## **STUDY AREA AND VIEWPOINT AGREEMENT**

## 5949 - Ford Airfield Issue 2

LDA Design have been appointed by Redrow Homes and Wates Developments to prepare a Landscape and Visual Impact Assessment (LVIA) for proposed development at Ford Airfield, policy SD8 of the Adopted Arun Local Plan (July 2018).

**To:** 'Nicola Longland'  
**Subject:** RE: Ford Airfield - LVIA Viewpoint Agreement

DRAWING TITLE
Figure 7.18 - Photograph Panel 12
Representative Viewpoint 12

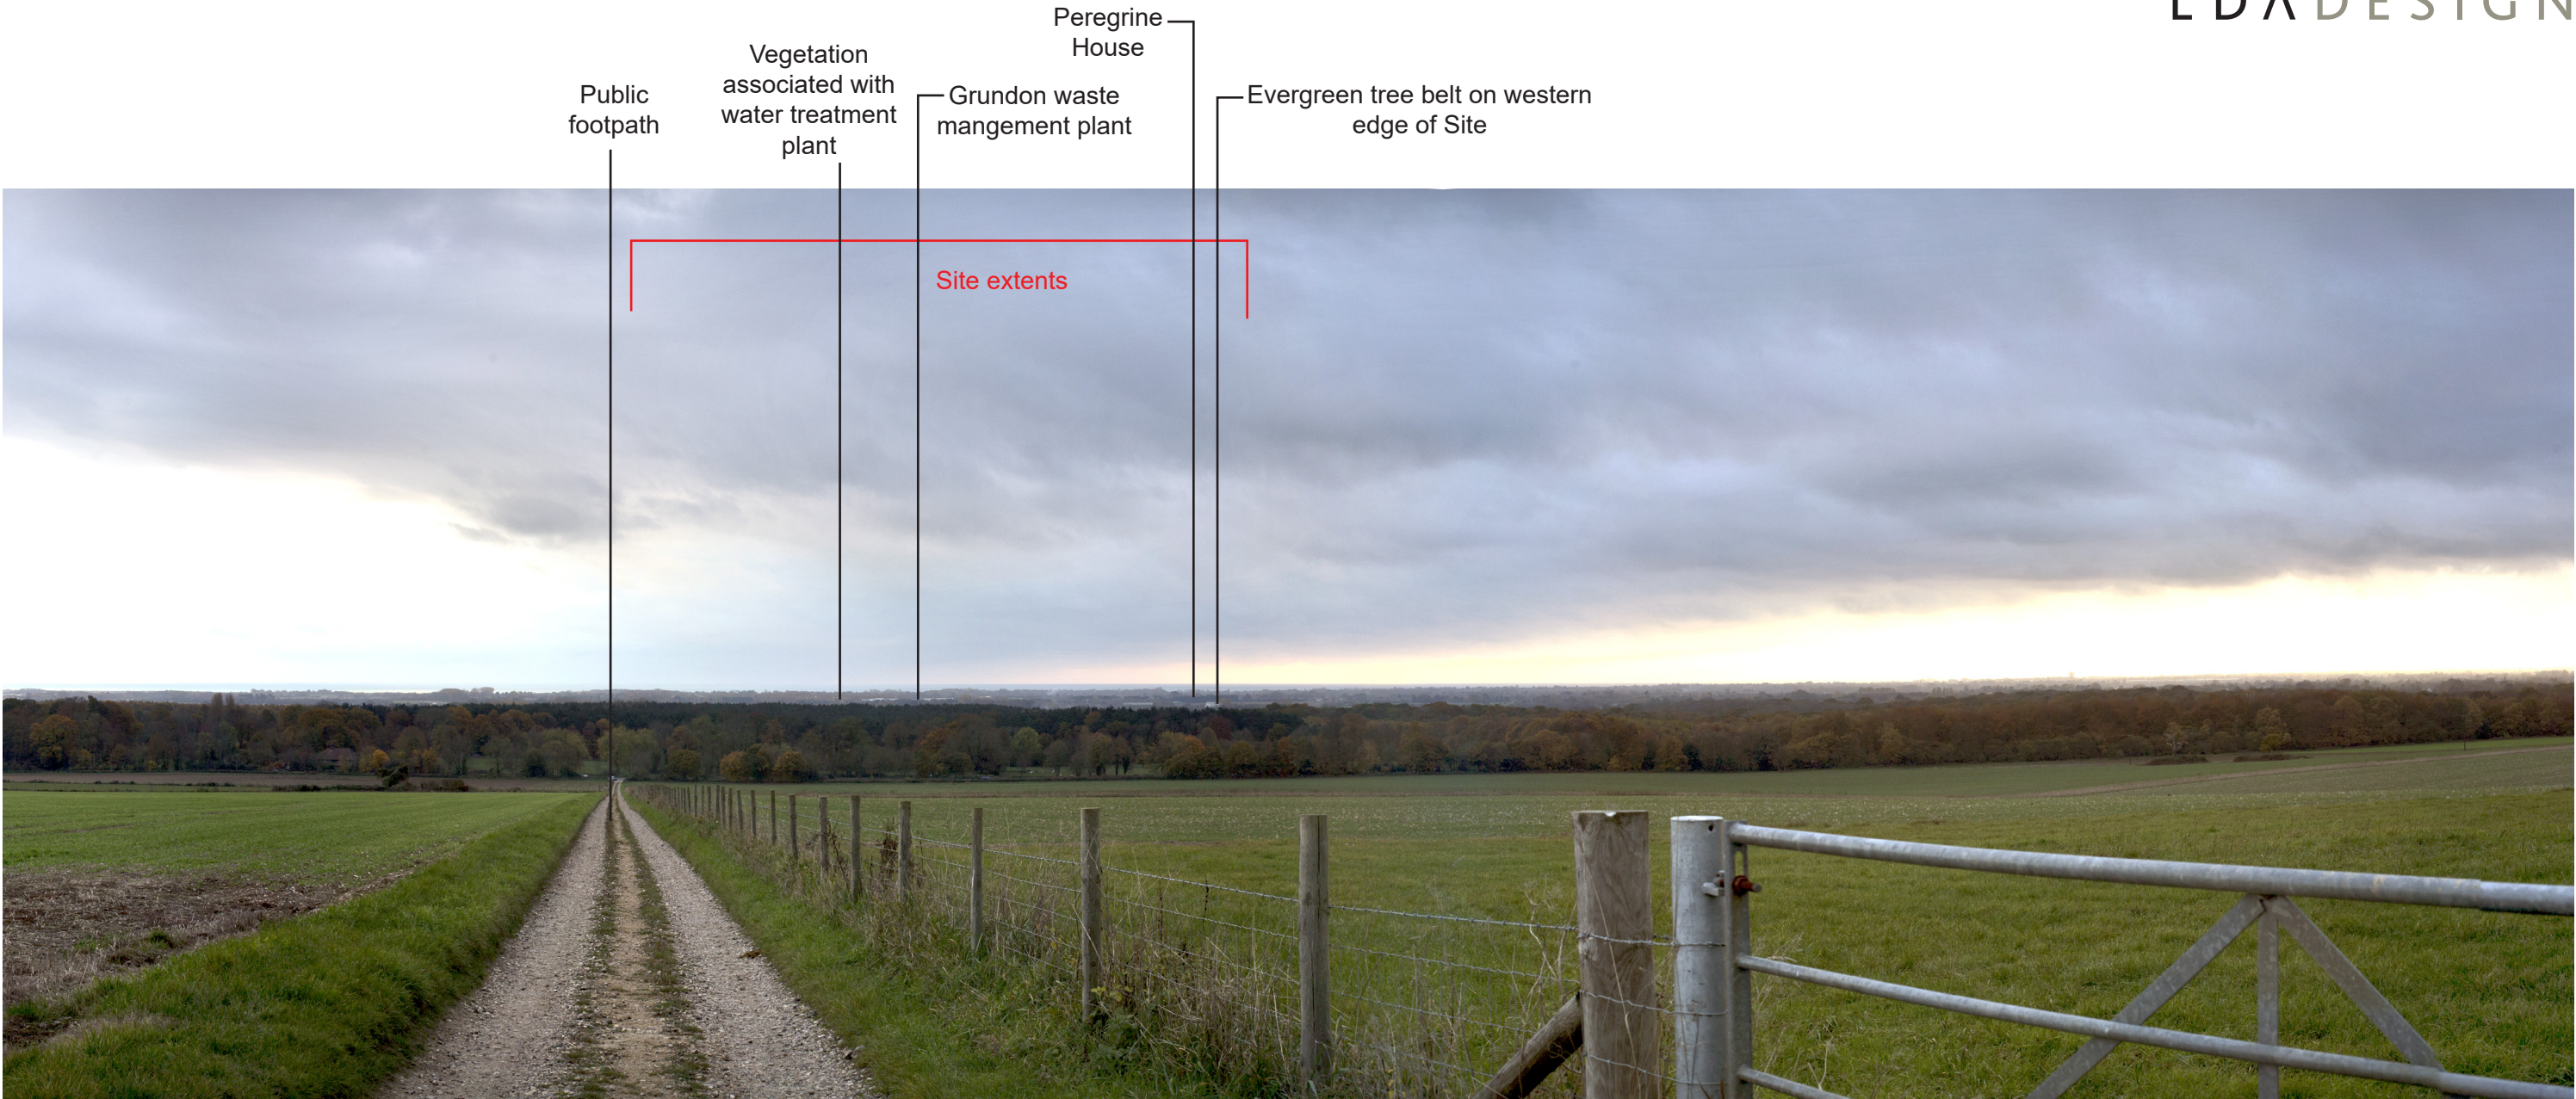
We will include an illustrative viewpoint from Bignor Hill within the South Downs which is approximately 10km north from the site. This will capture long distance views from the National Park. However, given the distance from the site and the wide panorama available, it is expected that effects will be Negligible and therefore will likely be scoped out within the assessment.

*"I think those listed 1-13 give a good representation however I would ask that they also consider further viewpoint to the ground rising to the North West of the site, beyond the Zone of Theoretical Visibility within the higher South Downs National Park to capture distant visual receptors."*

DRAWING TITLE
Figure 7.6:
Public Rights of Way and Representative Viewpoints

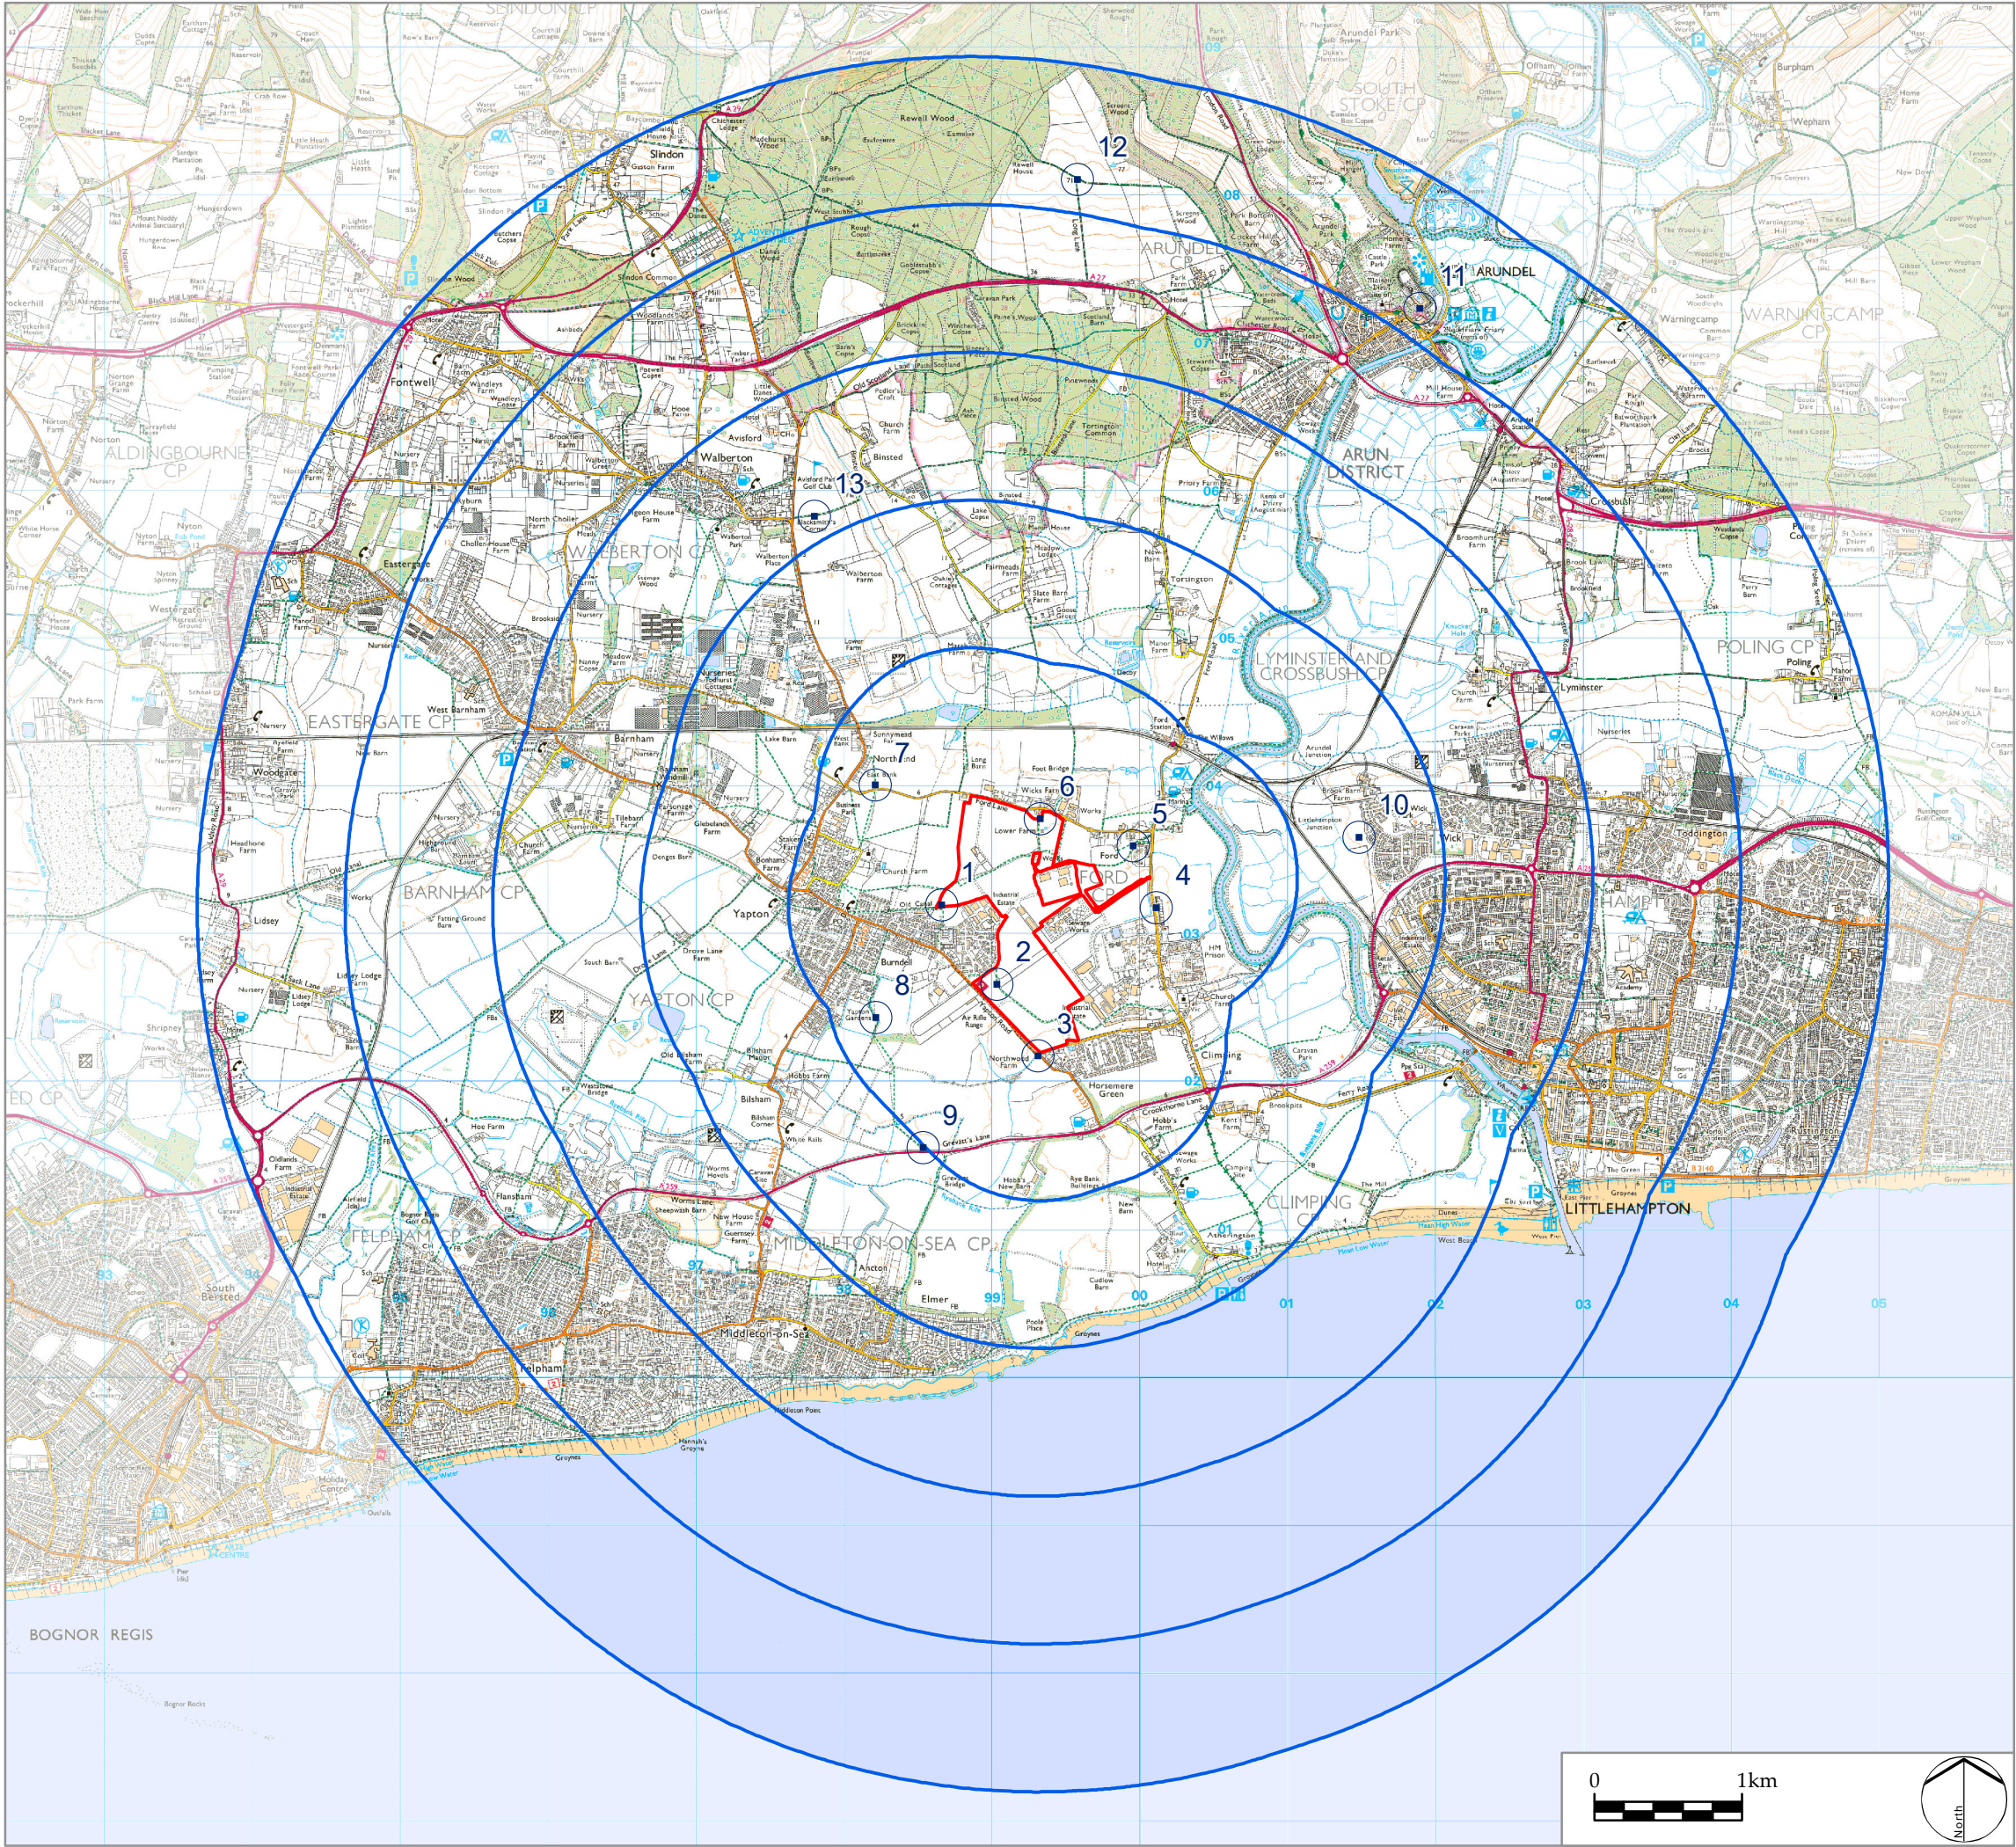
I have discussed this with Claire and she had identified an additional viewpoint that she felt should be considered in the LVIA which was from the north of the A259 on footpath 166 (south of viewpoint 8 and east of viewpoint 9).

With regards to the additional viewpoint from public footpath 166 north of the A259, we will look to take this close to the roadside so that is more representative of people using A259 (as well as public footpath users).
